CITY OF MERCER ISLAND

RE: Review Comments for File No. CAO17-010 – Hou Critical Areas Determination
4825 E Mercer Way, Mercer Island, WA 98040; King County Tax Parcel # 216200-0070

PROPOSED SITE PLAN, IMPACTS & MITIGATION PLAN

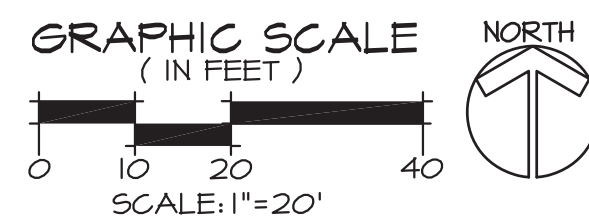
1. Please add the limits of disturbance onto the project plans and add the drip lines for the 80-inch Douglas fir (the eagle tree) and the adjacent 42-inch Douglas fir onto the project plans. The limits of disturbance and drip lines should be as provided in Attachment 2 – Tree Inventory/Conditions Spreadhseet of the arborist report by Gilles Consulting dated September 19, 2017.

4. Please indicate on the project plans where drainage from the proposed house and driveway will go.
5. It appears the exterior of the proposed house is too close to the proposed buffer. Identify the area of construction on the plans and determine what construction and future home maintenance activities will occur and how these can occur without disturbing the buffer. There will likely need to be more space between the proposed home and the proposed buffer than shown on the plans.
